# ***City of Albuquerque***

***Planning Department  
Transportation Development Services Section***

Re: Certification Submittal for Final Building Certificate of Occupancy for  
Arno Lofts, [K-14 / D84]  
400 Central Ave SE  
Architect's Stamp Dated

Re: Certification Submittal for Final Building Certificate of Occupancy for  
Arno Lofts, [K-14 / D84]  
400 Central Ave SE  
Architect's Stamp Dated 04/19/04

Site Development Plan
for Building Permit
Arno Lofts

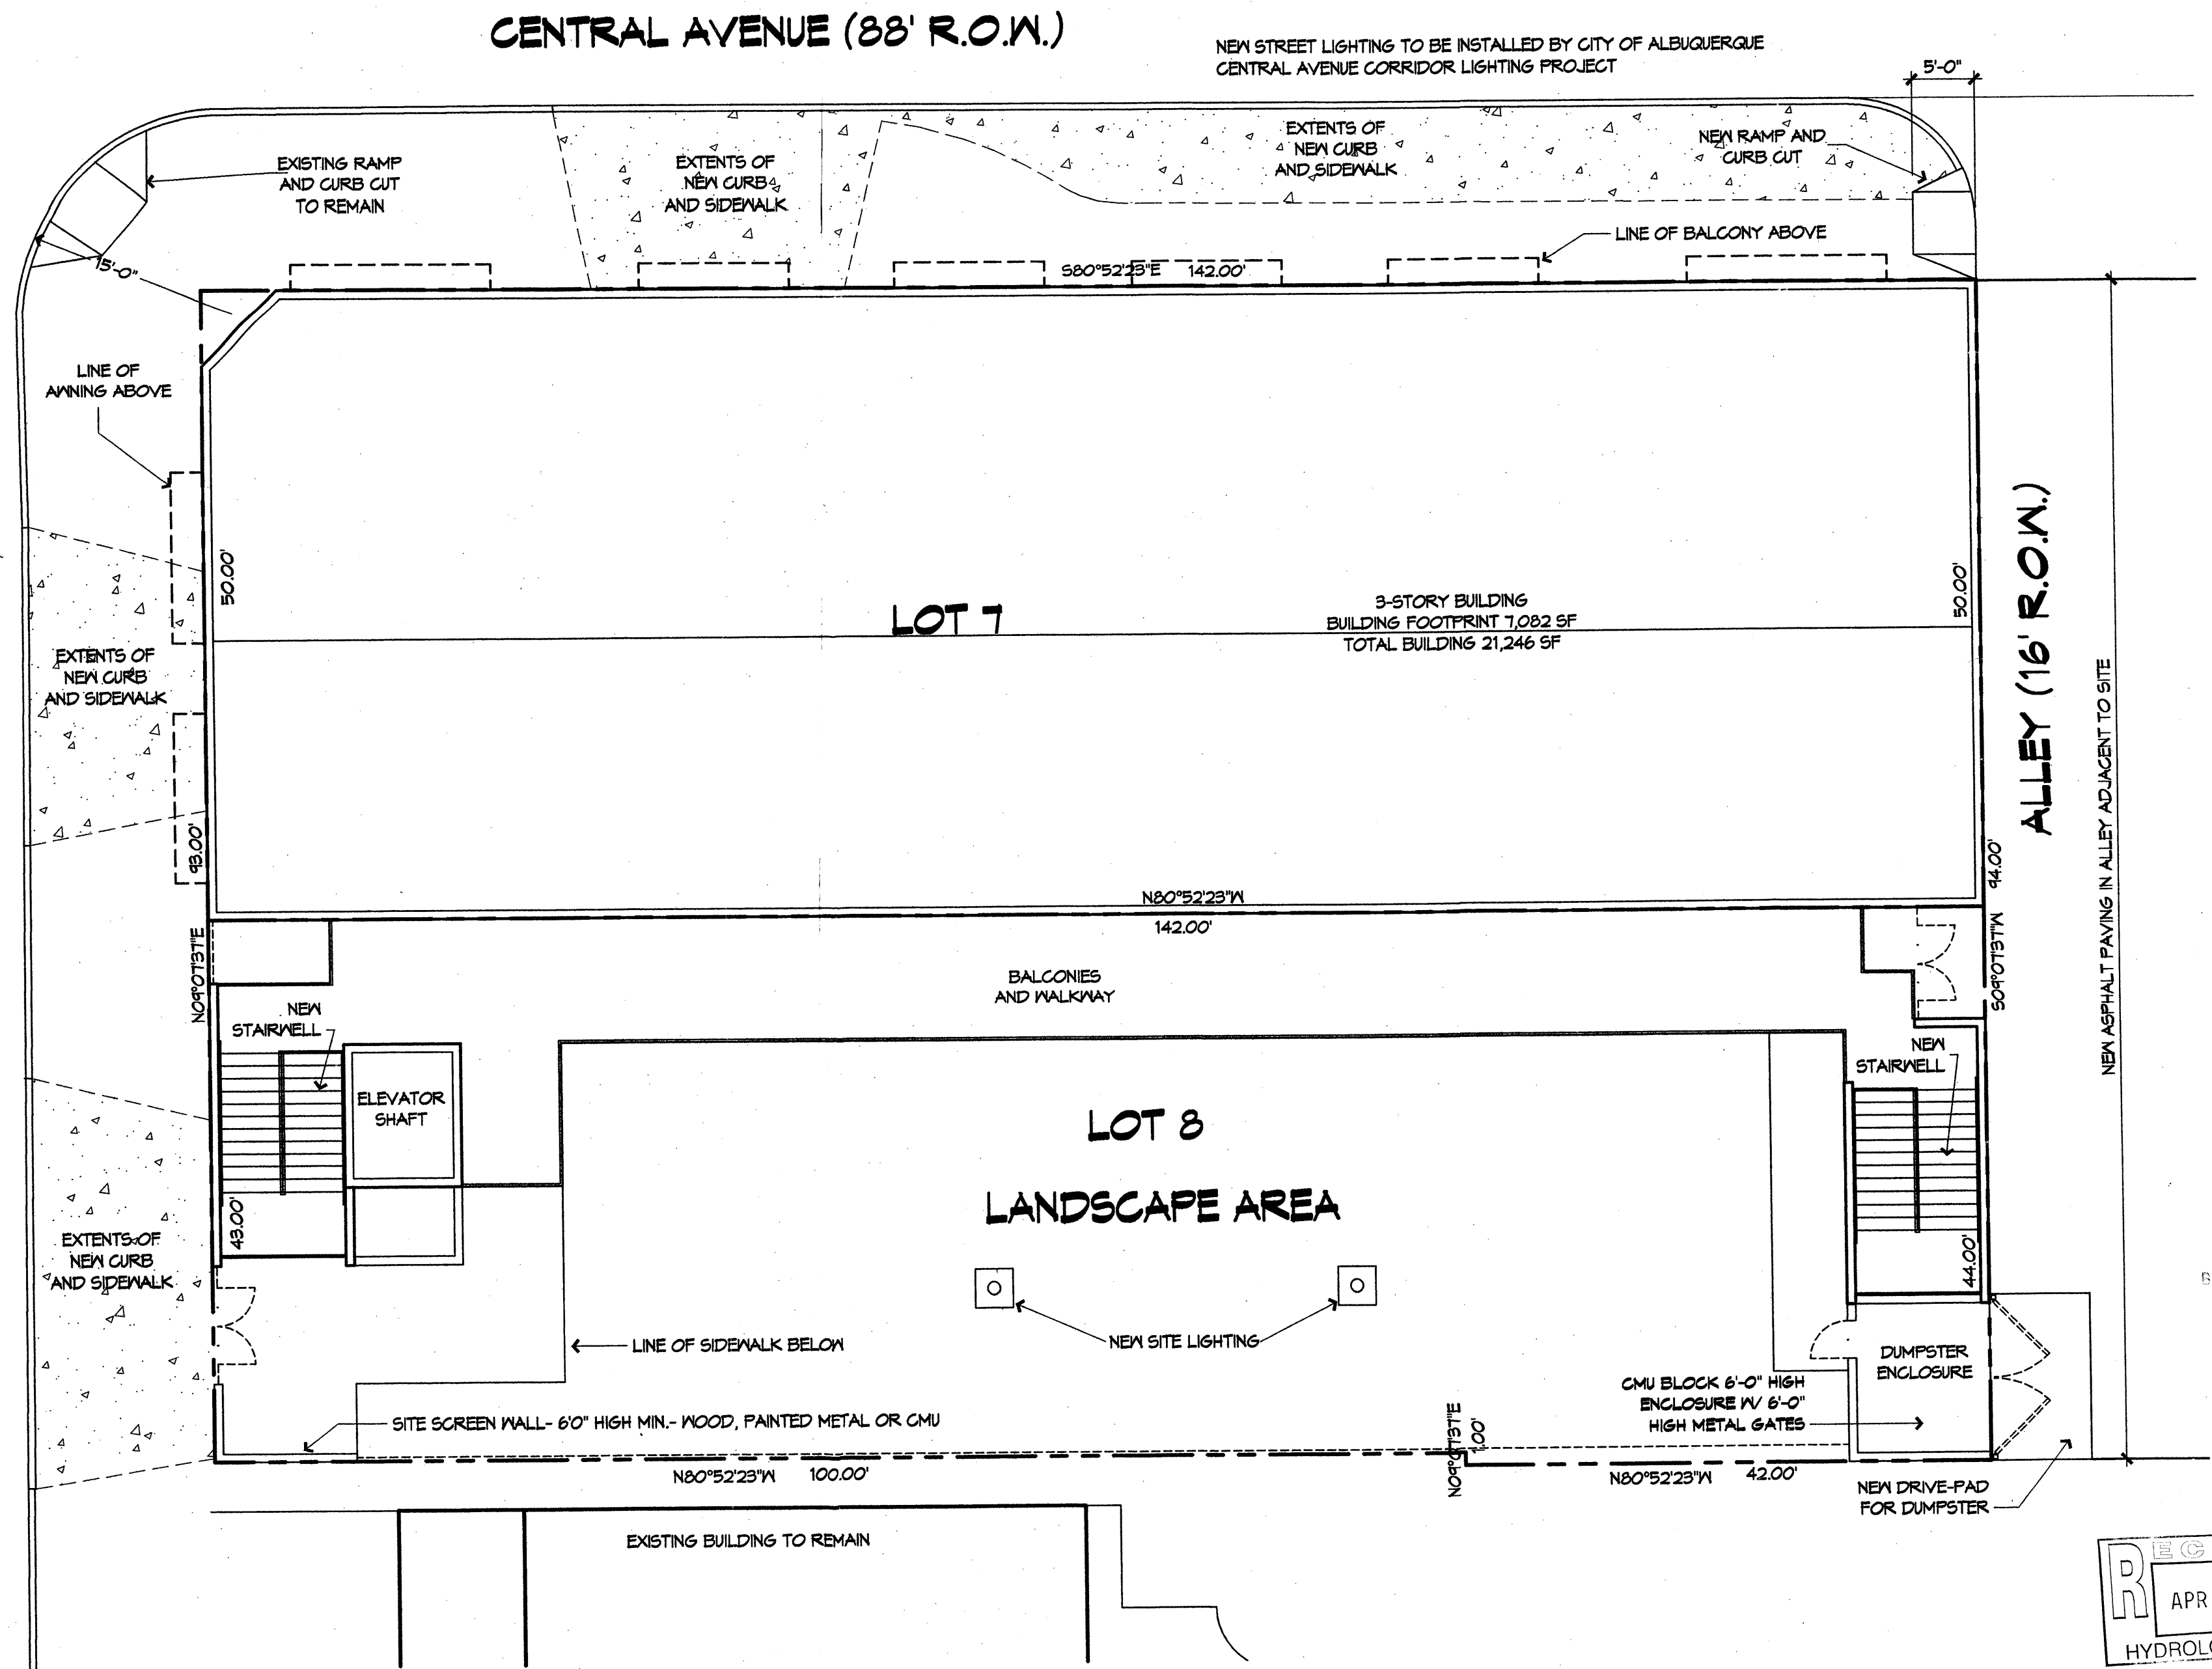
The TCL / Letter of Certification submitted on April 19, 2004 is not sufficient for acceptance by this office for final Certificate of Occupancy (C.O.). Upon field inspection, it was found that the proposed frontage of Central construction is not completed and has not been accepted by the City, as well as the alleyway construction adjacent to lofts. Please provide original signature on letter of Certification for next submittal.

The TCL (or DRB Site Plan) submitted for Final C.O. needs to be the exact copy of the approved TCL in the plan set approved for building permit. This will be the latest edition, which may have redlined comments, initialled and dated by the designer-of-record.

Resubmit acceptable package along with fully completed Drainage Information Sheet to front counter personnel for log in and evaluation by Transportation.
